Our Ref: S188010
Your Ref: FG/39/18/PL and FG/171/18/DOC
19th March 2019

Site Address: Worthing Peugeot, Littlehampton Road BN12 6PB

Development: *Demolition of existing property & outbuildings; erection of new Motor Dealership with Showroom, Offices & Motor Vehicle Workshop (including MOT) & new Head Office Facility adjoining the existing Peugeot building on site including associated hard & soft landscaping & associated supporting facilities.*

Further to the condition 3 imposed to the planning approval, please refer below to our response to the comments raised:

YEO AKSW XX GF DR C 9205

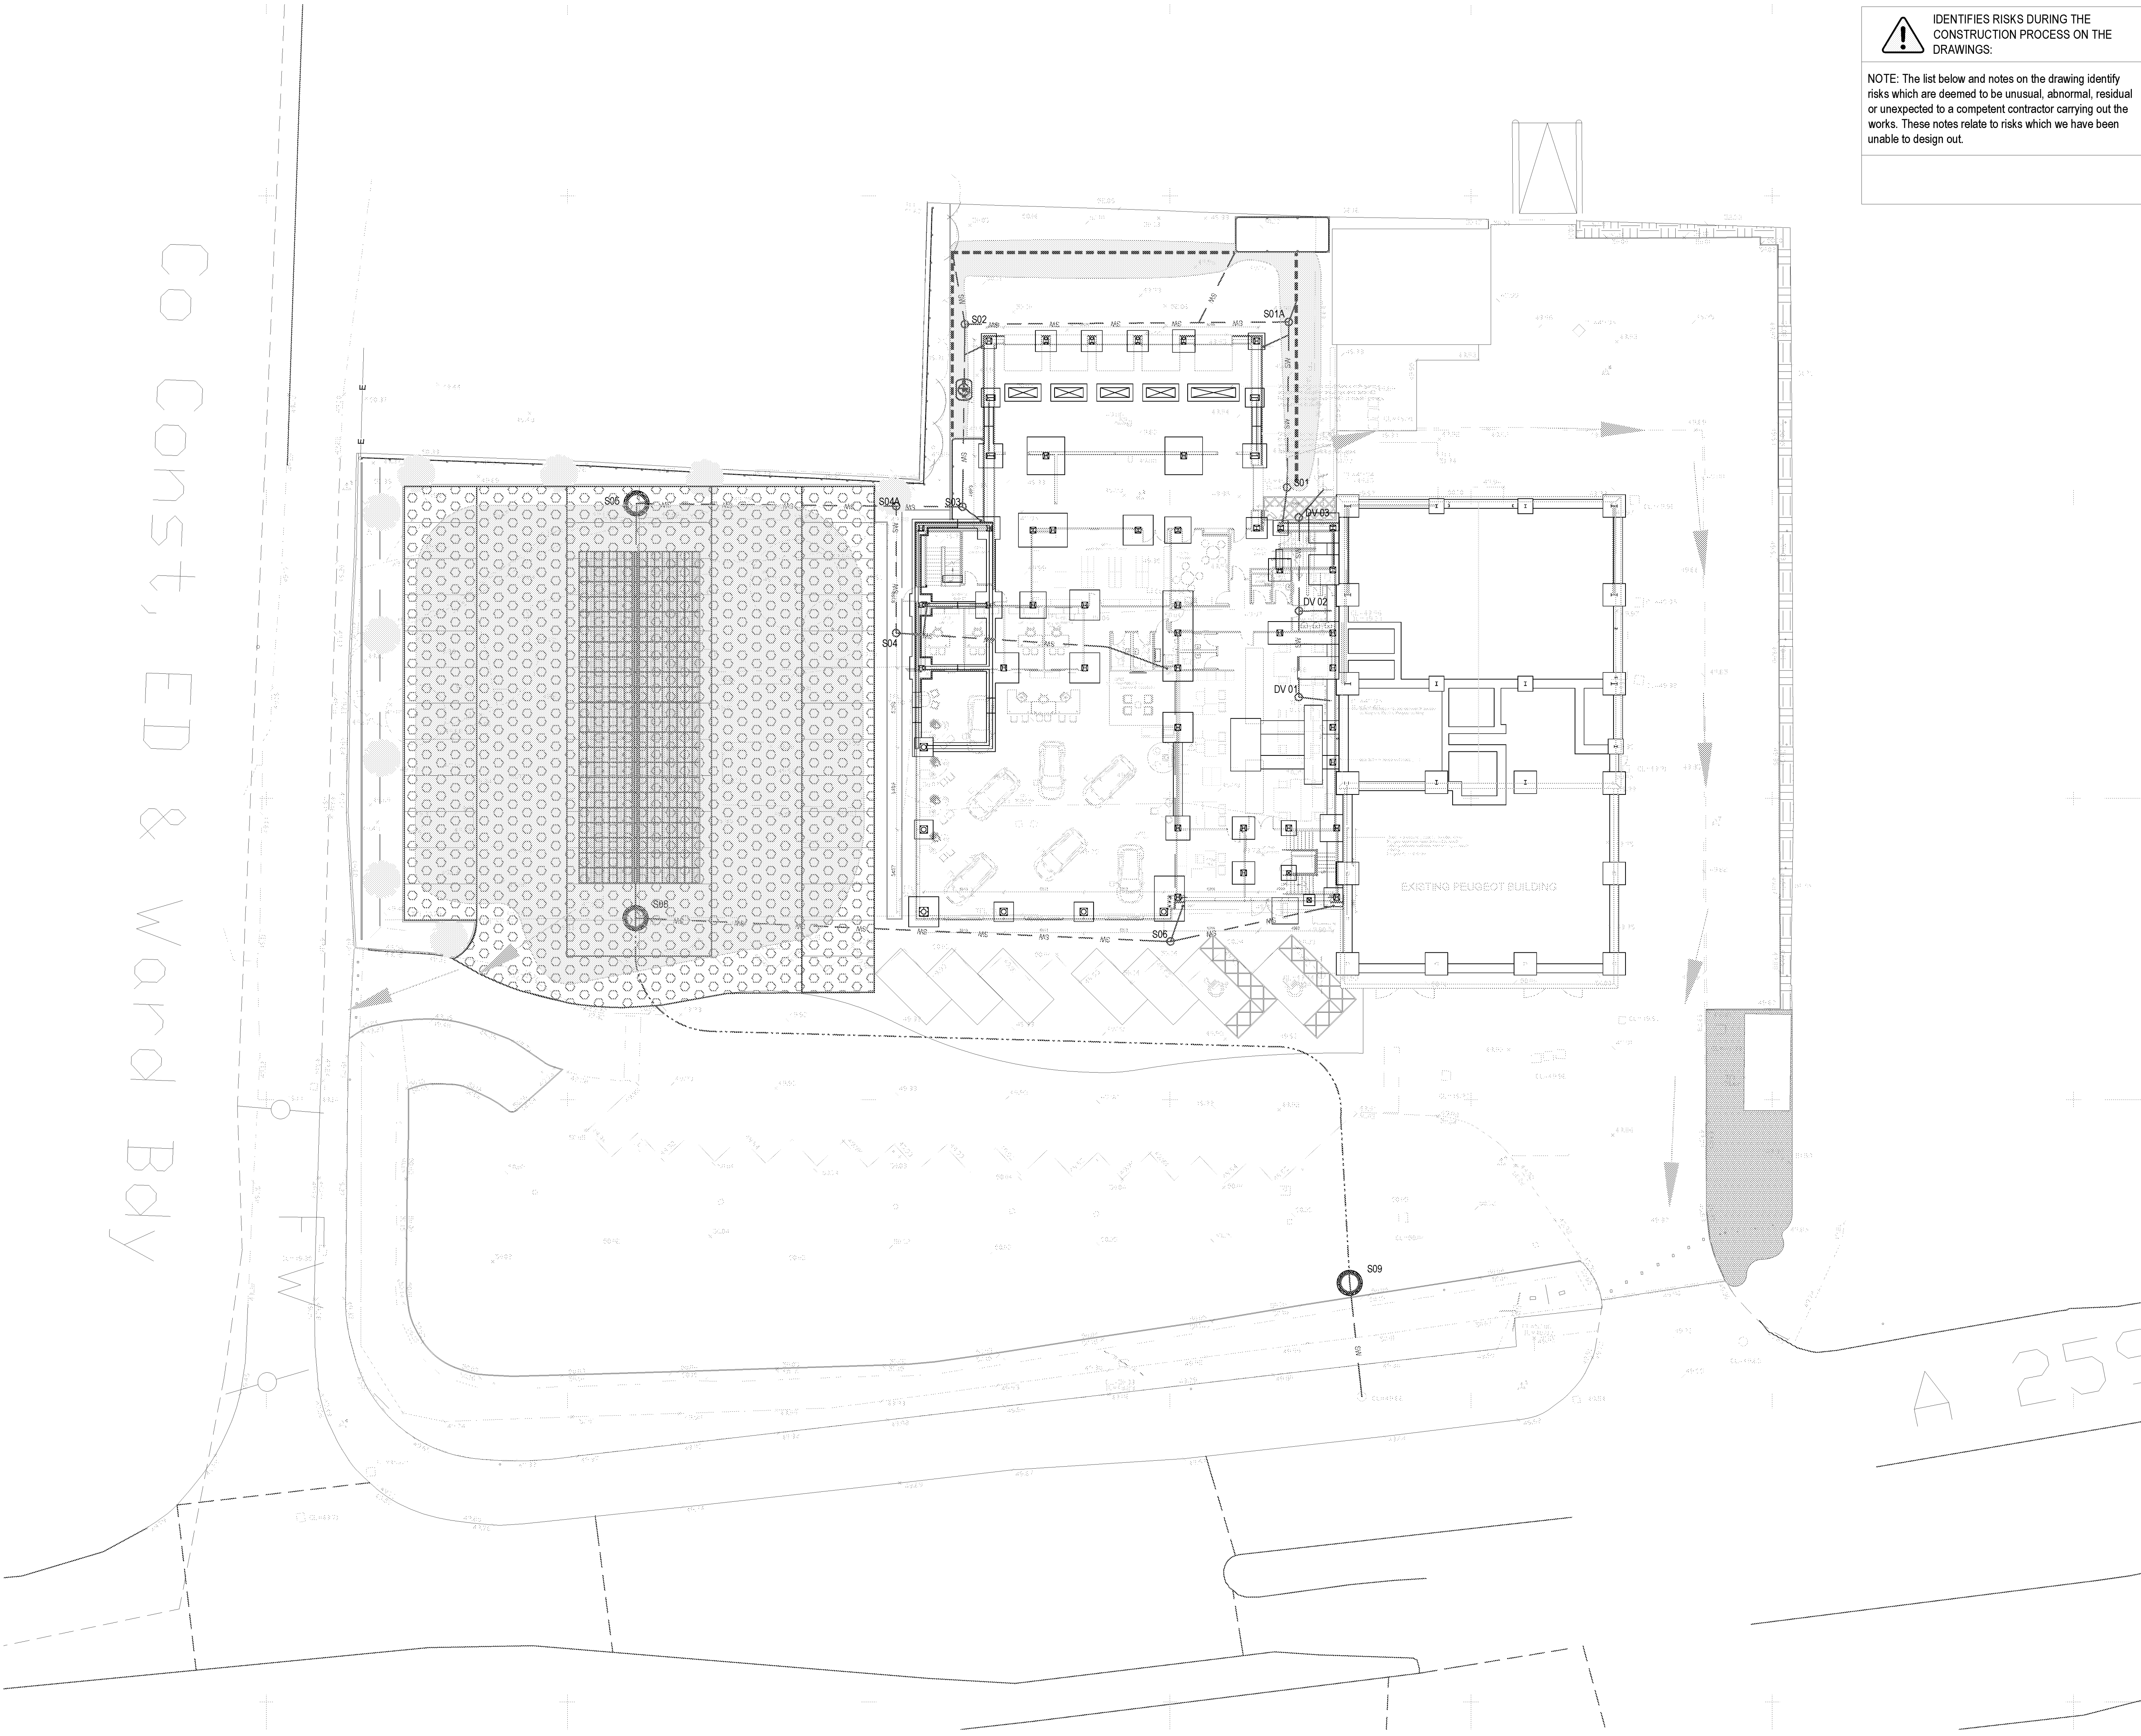
"Exceedance flow rates need to be demonstrated"

Exceedance flow paths drawing has been included in the drainage strategy document, please refer to Drainage Strategy, Rev, P05, Appendix C.

YEO · AKSW · XX · XX · DR · C · 9252 - C02

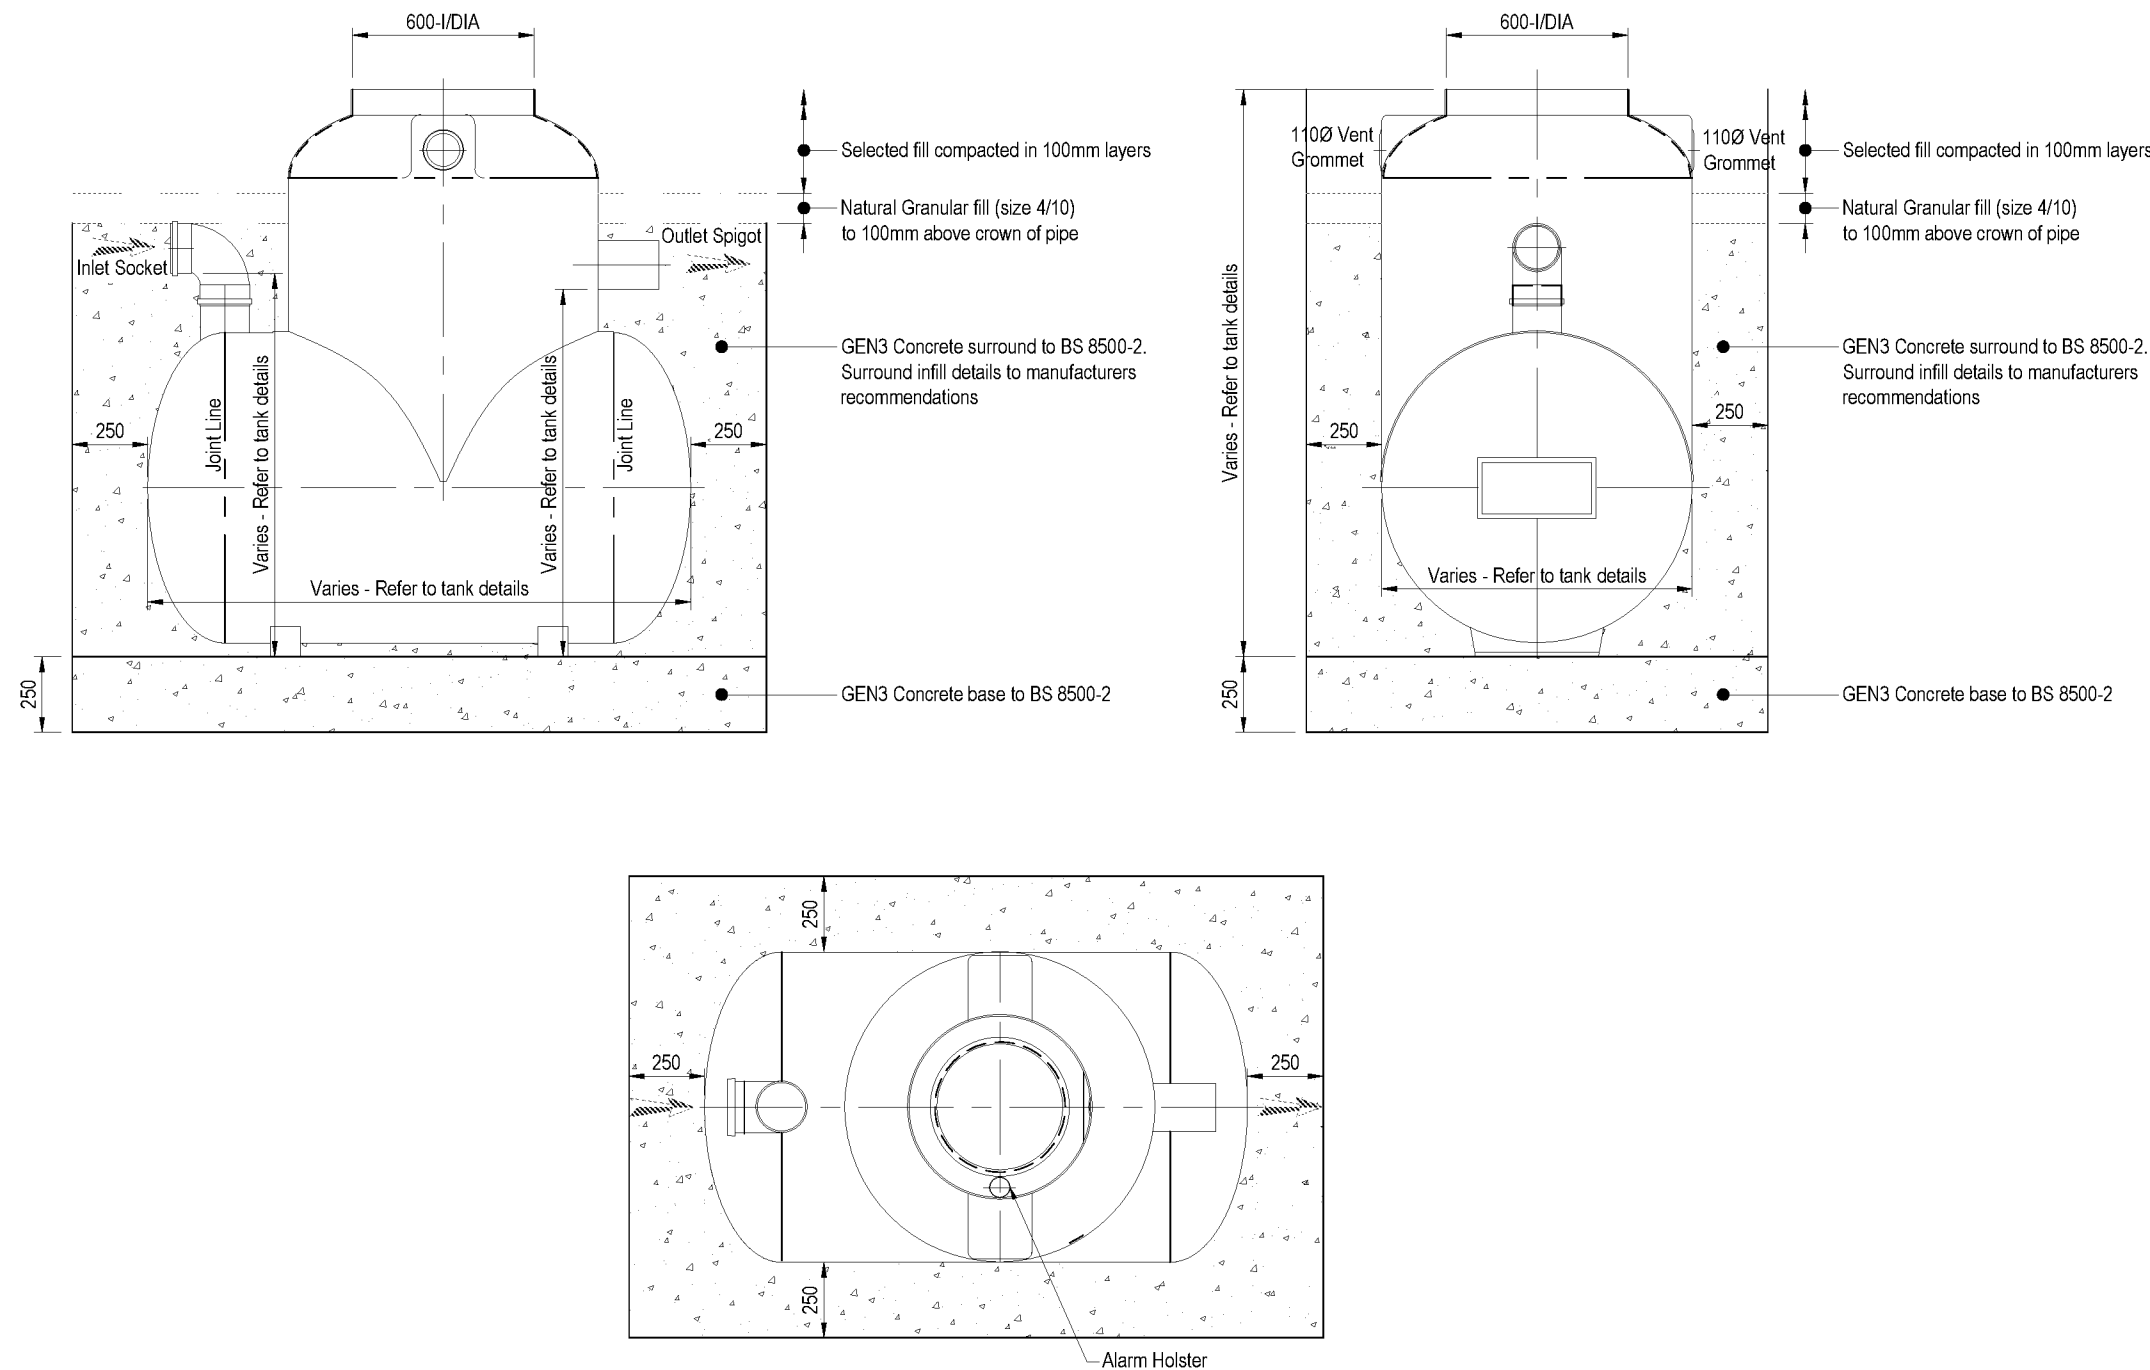
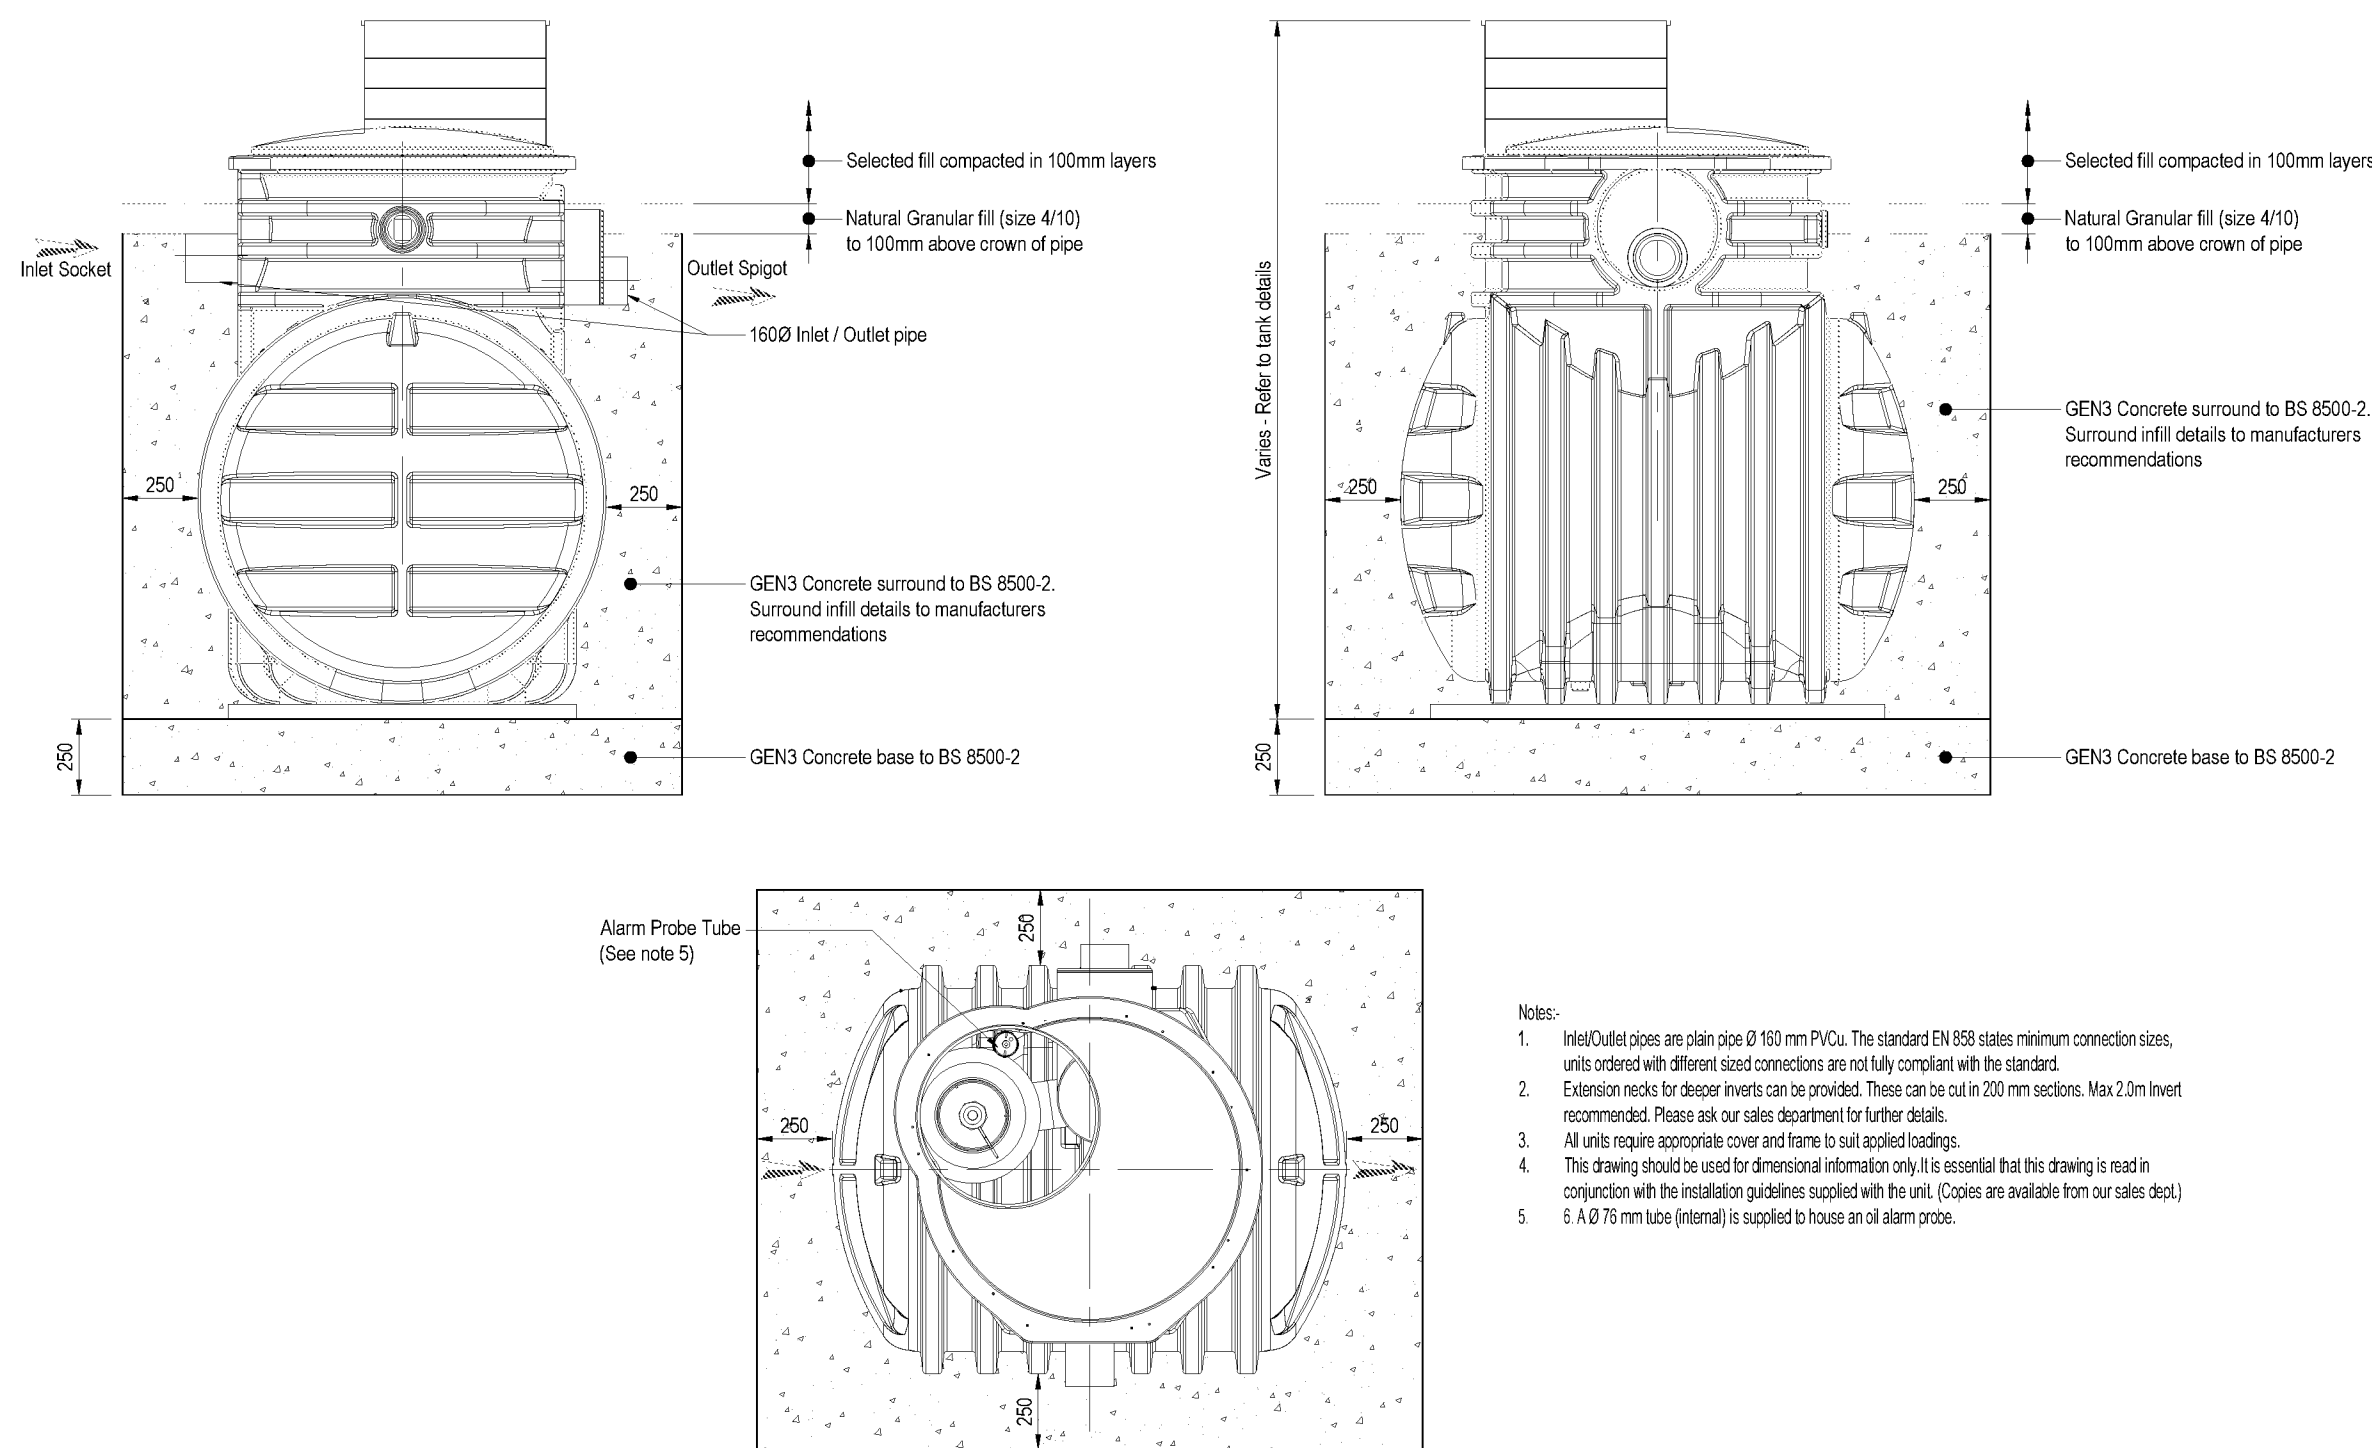
"Construction detail drawings supplied"

Drainage construction details have been included in the drainage strategy document, please refer to Drainage Strategy, Rev, P05, Appendix C.
